## Appeal Decision

**Appeal Ref: APP/R5510/X/24/3353221**

**45 Kingsway, Hayes UB3 2TT**

- The appeal is made under section 195 of the Town and Country Planning Act 1990 (as amended) against a refusal to grant a certificate of lawful use or development (LDC).
- The appeal is made by Mr Jaideep Singh against the decision of the Council of the London Borough of Hillingdon.
- The application ref 78730/APP/2024/1036, dated 21 April 2024, was refused by notice dated 12 June 2024.
- The application was made under section 192(1)(b) of the Town and Country Planning Act 1990 (as amended).
- The development for which an LDC is sought is gym/playroom and storage area in rear garden.

TITLE  
FLOOR PLAN

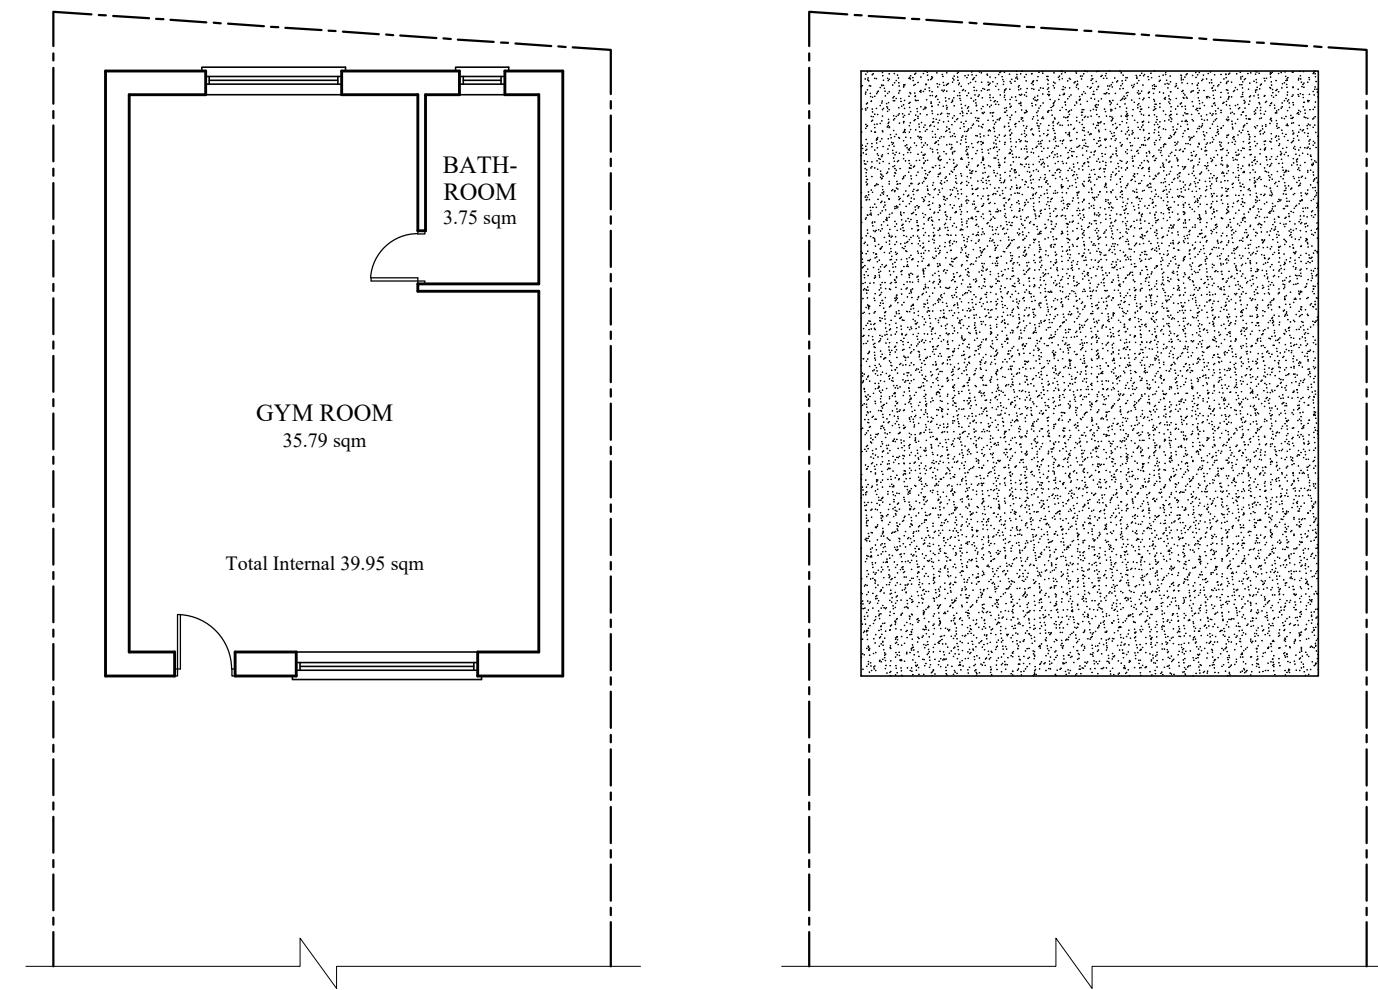
6. The proposed building would be at the rear of the rear garden and would be, externally, about 48 square metres. The Council has commented that the dwellinghouse has a lesser footprint of about 42 square metres, but it has two stories and has a floor area of about 84 square metres. The size of the proposed outbuilding is not a reason to withhold an LDC. In this regard it is worth noting that residents of modest dwellings, rather than residents of large dwellings, are those that may need to supplement their dwellinghouse to fulfil their recreational wishes and space needs.

7. The proposed use of the outbuilding is confused. The application form describes the use as gym/playroom and storage whereas a plan drawing indicates that the use would be gym and bathroom. Though gym and playroom may be regarded to be ancillary uses there must be a genuine reason for space to be created for these uses to be incidental to the enjoyment of the dwellinghouse. The genuine reason must relate to those who live in the dwellinghouse. There is no information, other than the name of the Appellant, about who lives in the dwellinghouse.

8. If the outbuilding would be used partly as a playroom is this to provide playspace for young children who live in the dwellinghouse ? Is there a specific need for a gym to fulfil the physical exercise needs of residents ? What needs to be stored in the outbuilding that can't be stored in the dwellinghouse ? These are questions that need answers to be able to judge whether the use or uses of the outbuilding would be incidental to the enjoyment of the dwellinghouse. The need for bathroom facilities would arise only after use of gym equipment and it has not been explained why bathroom facilities in the dwellinghouse could not fulfil this requirement.

9. There is insufficient information to be able to judge whether the proposed outbuilding would be genuinely and reasonably required to accommodate uses that would be incidental to the enjoyment of the dwellinghouse.
